WEST SUSSEX COUNTY COUNCIL CONSULTATION

TO:	Arun District Council FAO: Amy Myer
FROM:	WSCC - Highways Authority
DATE:	13 October 2021
LOCATION:	Land at Hawthorn Road Wick Littlehampton BN17 7HF
SUBJECT:	LU/294/21/TEL Prior Notification under Schedule 2 Part 16 Class A for a proposed 15.0m Phase 8 monopole C/W wraparound cabinet base and associated ancillary works.
DATE OF SITE VISIT:	n/a
RECOMMENDATION:	Advice
S106 CONTRIBUTION TOTAL:	n/a

Title: **210 PROPOSED SITE PLAN**

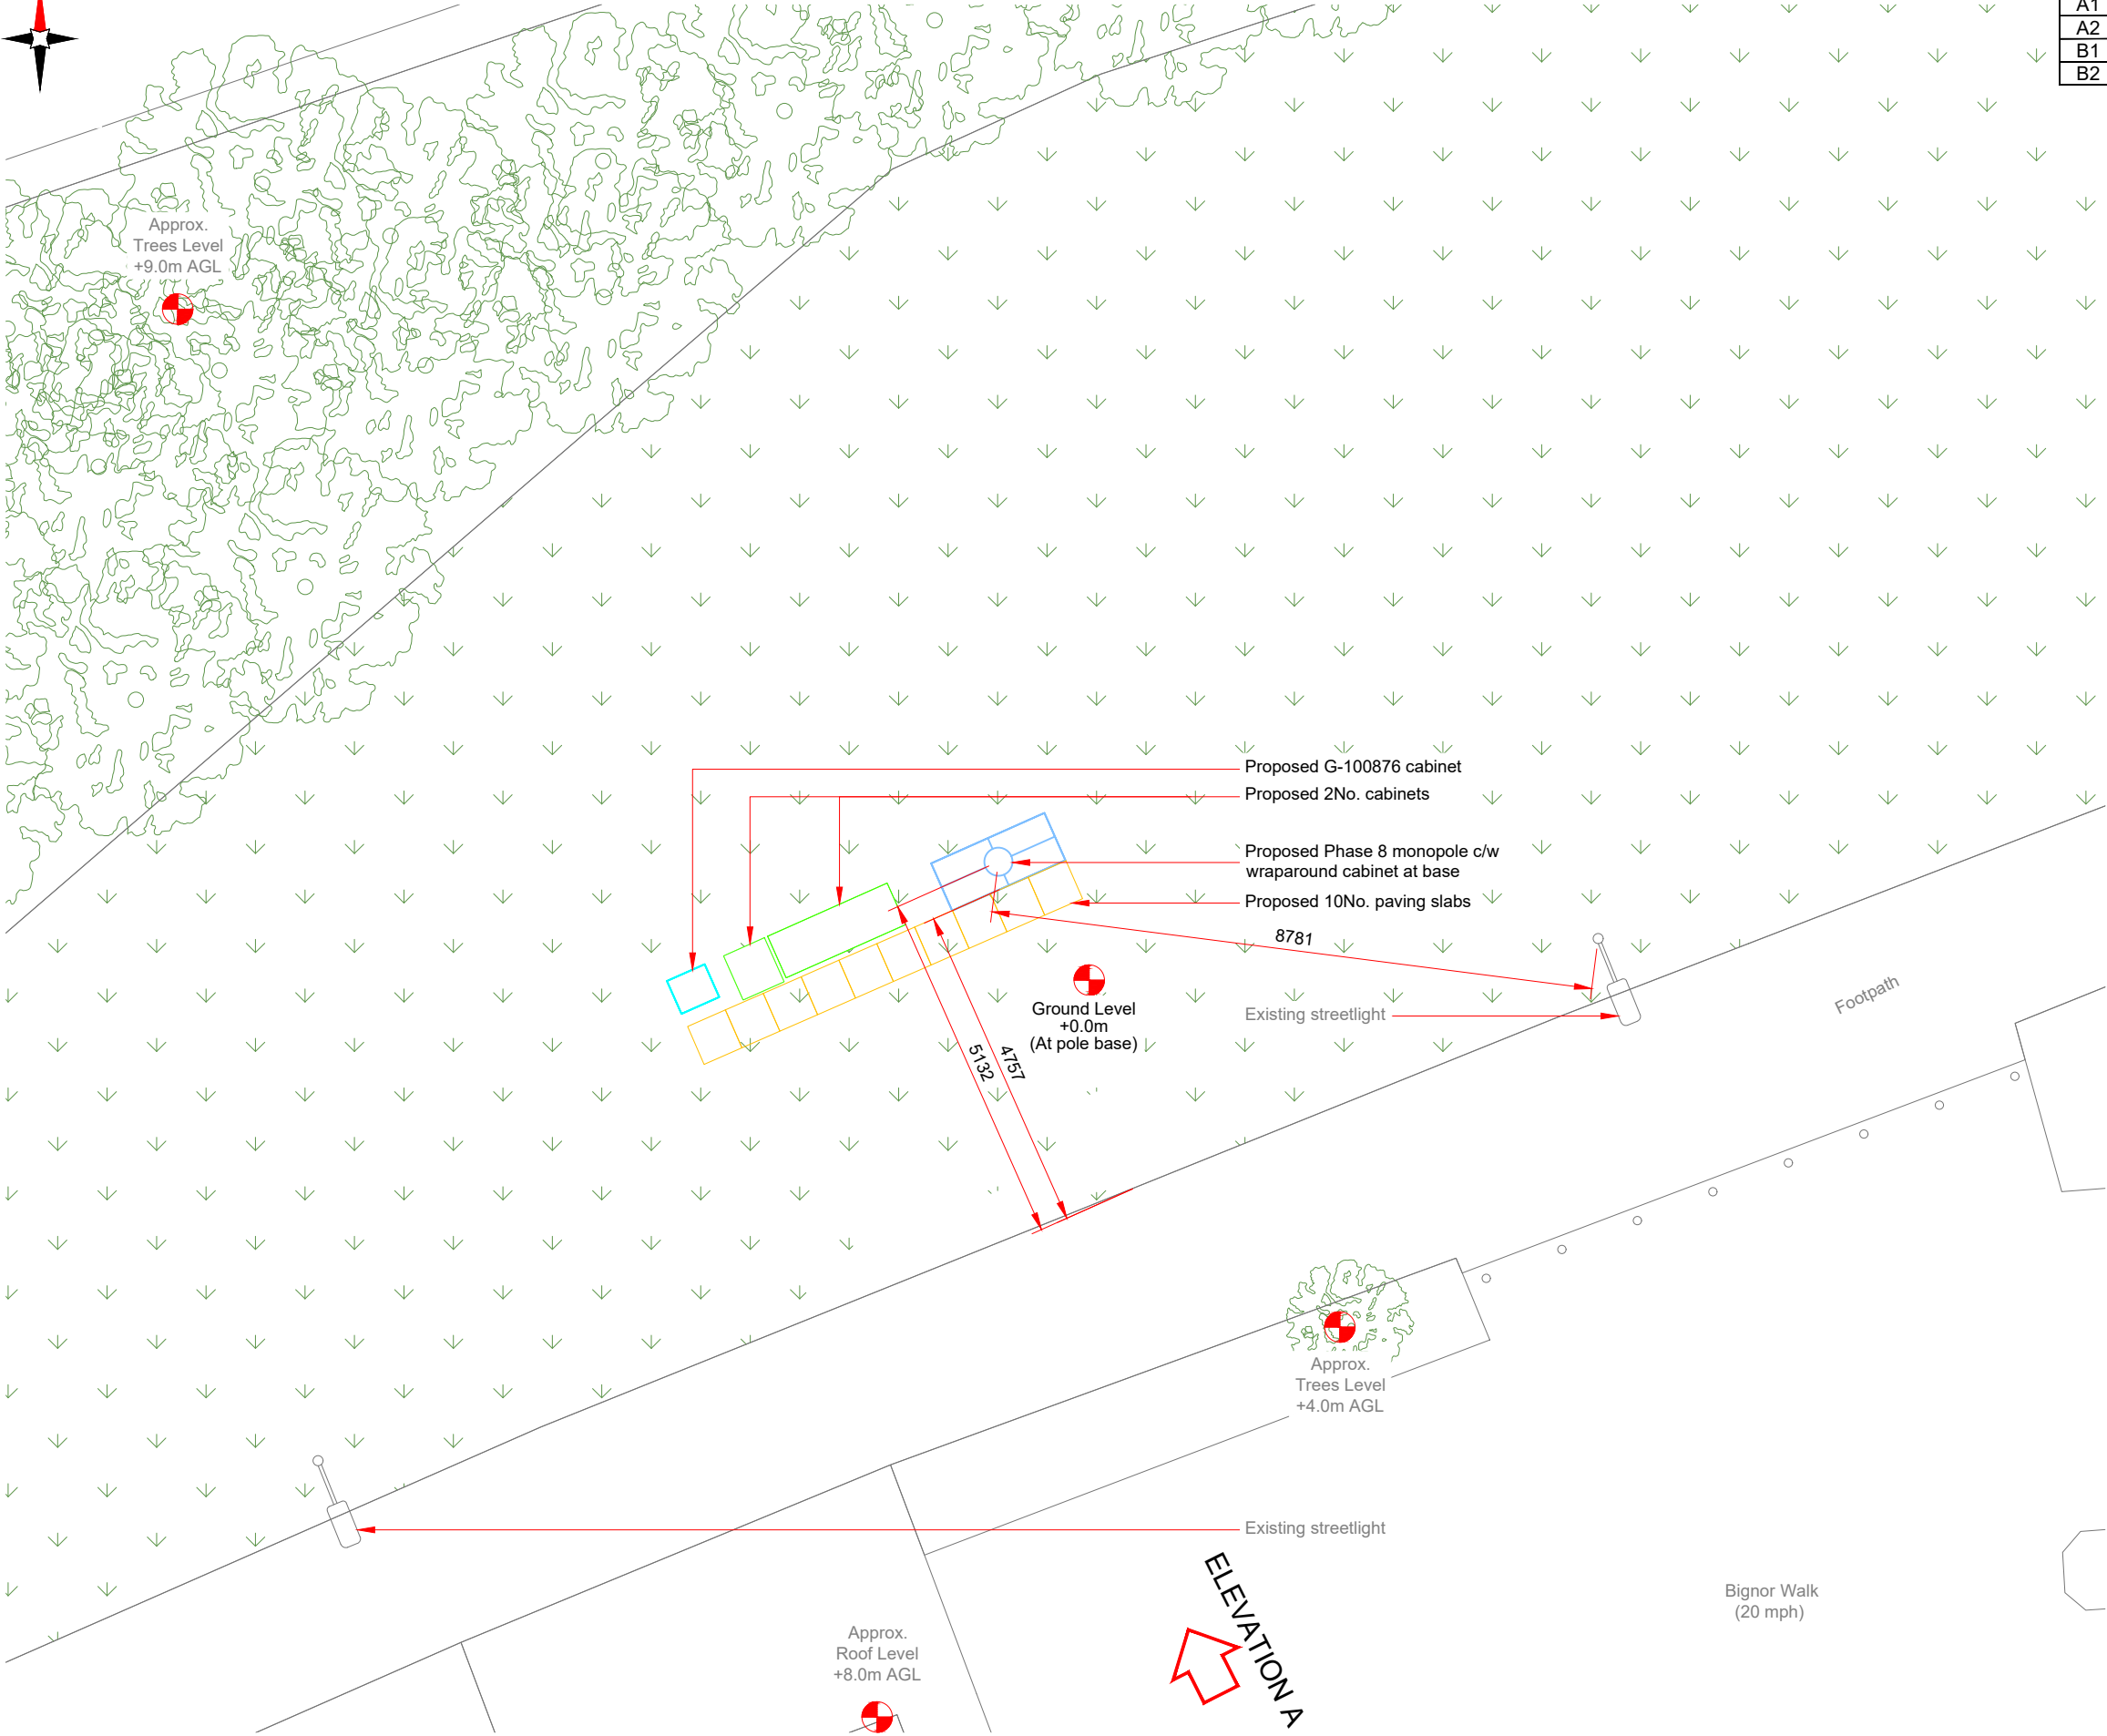
The proposed monopole and cabinet are located within the highway boundary. They are not anticipated to obstruct visibility for vehicles travelling along the A259.

The proposed equipment will be located on verge that has a footway. This proposal is not anticipated to result in an obstruction to any pedestrians who may be utilising or be seeking refuge within the existing footway.
